## Hearing Transcript

<b>Project:</b>	Morgan and Morecambe Offshore Wind Farms Transmission Assets
<b>Hearing:</b>	Issue Specific Hearing 2 (ISH2) – Part 3
<b>Date:</b>	29 July 2025

Figure 1.6: Biodiversity benefit area at Lea Marsh Fields

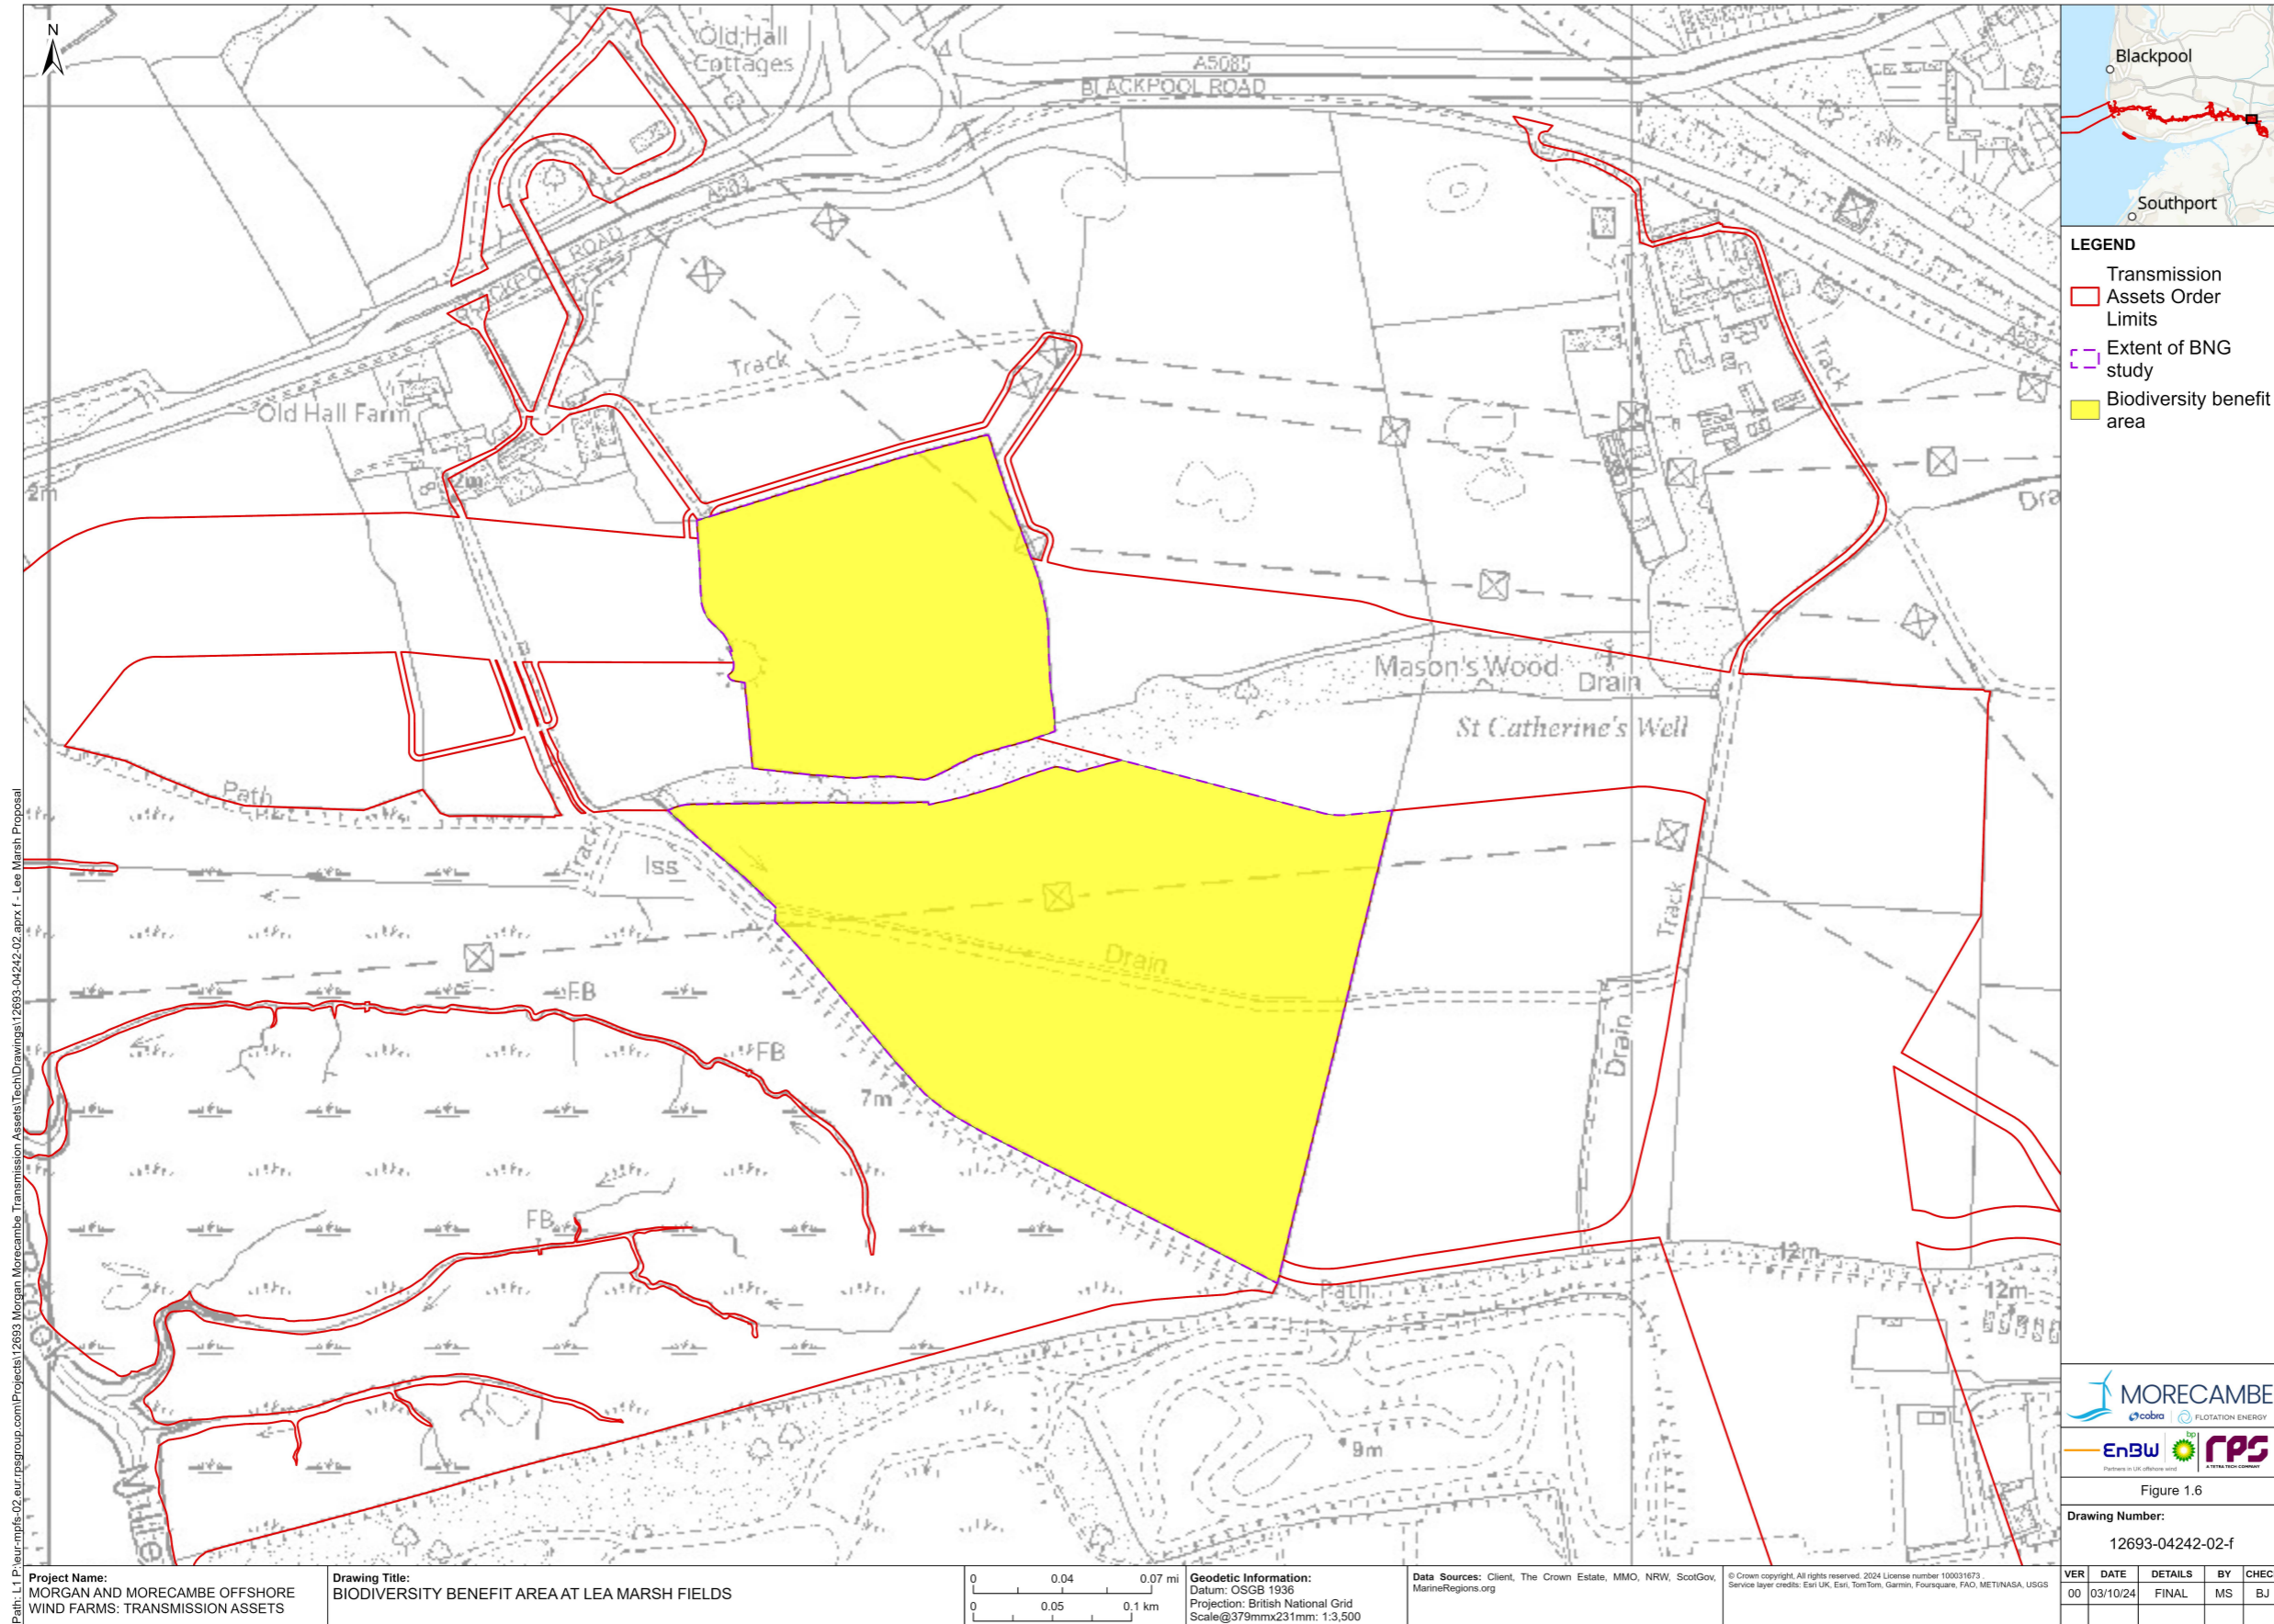
And it's going to focus on figure 1.41.5 and 1.6. So maybe we can start with 1.6. And uh, the question to the applicant. Could you briefly describe your biodiversity net gain strategy? Um, with a brief explanation and description of each area.

However, could the applicants provide the reasoning for the proposed percentages in your biodiversity benefit strategy. So for example, we are almost at 60% increase for the habitat. And I would like to understand your reasoning.

why not 10%? Why so much over the 10%?

Okay. Um, your outline wildlife hazard management plan, uh, describes specific restrictions that are needed to reduce or manage the potential aviation risks when it comes to that area.

So your outline wildlife hazard Management plan, um, describes specific restrictions and what you are going to do or not going to do as to manage potential aviation risks, and it reads as if there is quite a few things you can't do because they will increase the risks to the planes. So

with part of land, with so many restrictions connected to it, why do you consider this to be the most effective enhancement strategy for the area?

Wouldn't it work better if it was an enhancement outside of the restricted zone?

So I don't know, you know, there's no detailed designs of these sites yet to influence that. So that's that's an issue that we don't understand what the risk will be. Um, I think our thoughts on this we put out in submissions before is, um, you know, the site selection process hasn't set out why this airport needs to be where it is. Um, there's no need for being through providers. It's not a statutory requirement here. Um, and if the applicants are seen as a 60% BNG, there's scope to reduce that if they still want to provide some.

Benji, we don't understand why alternative locations haven't been looked at that would avoid the risk altogether.

Um, and I, I urge the examining authority to request that of the applicants. Um, then there was the point that the this mitigation area, this particular one has already I didn't understand if it's already been designed to discourage bird birds visiting it, or that is a change since the application was made, because if they didn't know about the risk of bird strike when preparing the application, why would they have designed it to avoid? But third strike, it doesn't make sense.

So I think it's a change since the application was made. Which if I'm right, means they should really recalculate the biodiversity score because they're now downgrading the environmental looks of quality of the site by making not have tall grass and not have reeds and have smaller ponds and all these sorts of things, surely that's going to reduce the score. So that needs to be recalculated even on the current calculations. But I say that it's much lower than it should have been in the first place.

Uh. Good afternoon. Uh, my name is Joe Atkinson. I'm a terrestrial ecologist working for Tetra Tech, speaking on behalf of both the applicants. Um, so just to summarize, the biodiversity net gain strategy, um, is presented in the biodiversity benefit statement, and it includes a range of measures that will be delivered at both the Morecambe and Morgan onshore substations. Um, plus habitat enhancements at the Leigh Marsh Fields Biodiversity Benefit Area, which is shown in figure figure 1.6.

Joe Atkinson on behalf of both the applicants. So the calculation has taken into account, um, the delivery at Morgan and Markham onshore substations. And that's separated out in the biodiversity benefit statement. And then the additional provision at Lee Marsh fields, um, is also separated out

between the projects. So there is a bit of a discrepancy between what's delivered at each of the substations, for example, at the Morgan onshore substation, what was delivered, um, for the habitat enhancements at that substation would not deliver 10%.

So therefore, a greater proportion of the biodiversity benefit at Lee Marsh fields is apportioned to that site. Um, and the areas were calculated based on the whole of that land parcel that they marsh fields, which does result in a in an over delivery of percentage units when it's calculated.

stakeholders would look to. So we've designed it. And that was updated at deadline too. Um, so the the ponds within the biodiversity benefit area are designed to discourage the larger, larger wader species. Um, and there's like woodland areas within that indicative area to ensure that those larger bird species are not attracted to the area.

Laura Martin on behalf of the applicants is. It's just what I've just said. We've already designed it. So. So it doesn't attract the larger species that by in Blackpool Airport are worried about. And also when you're looking at doing biodiversity net gain for a scheme, it should be in closest proximity to that scheme. And if you were to cite it outside of that 13 kilometre radius, it wouldn't have the same effect.

Uh, Joe Atkinson, on behalf of the applicant. Um, yes, that's true, but for the biodiversity net gain calculation, if you deliver it further away from where your impact is, then it attracts a higher penalty clause in terms of the delivery. So obviously that metric is directing you to deliver it as close as possible to the area of impact by penalizing you if you deliver it further away.
